Application for a Non-Material Amendment Following a Grant of Planning Permission

First floor rear extension

S.23/0454/HHOLD

Drawing 1529.2.1  
 95 Thrupp Lane  
 Stroud  
 GL5 2DG

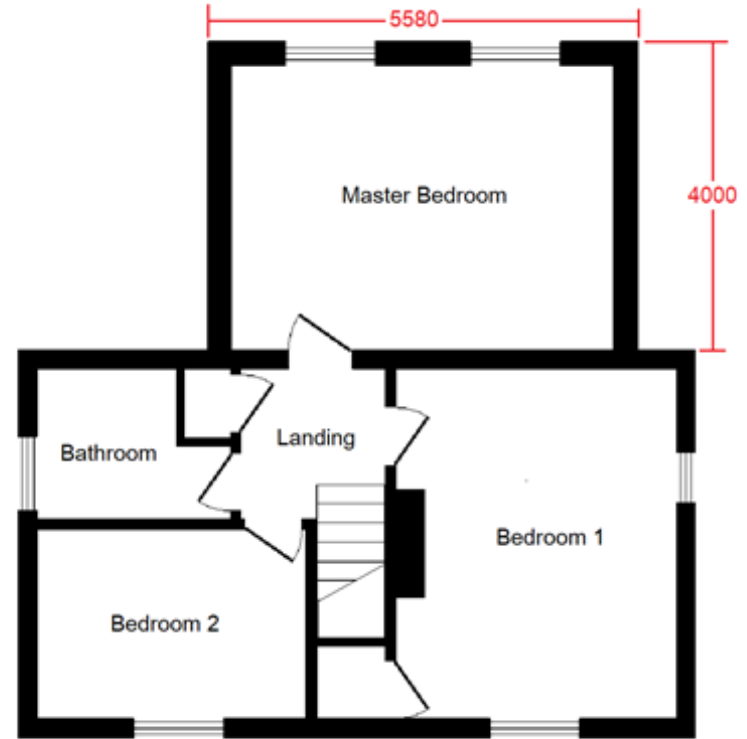
Extend ground floor to match approved first floor footprint

To simplify construction on advice from structural engineer
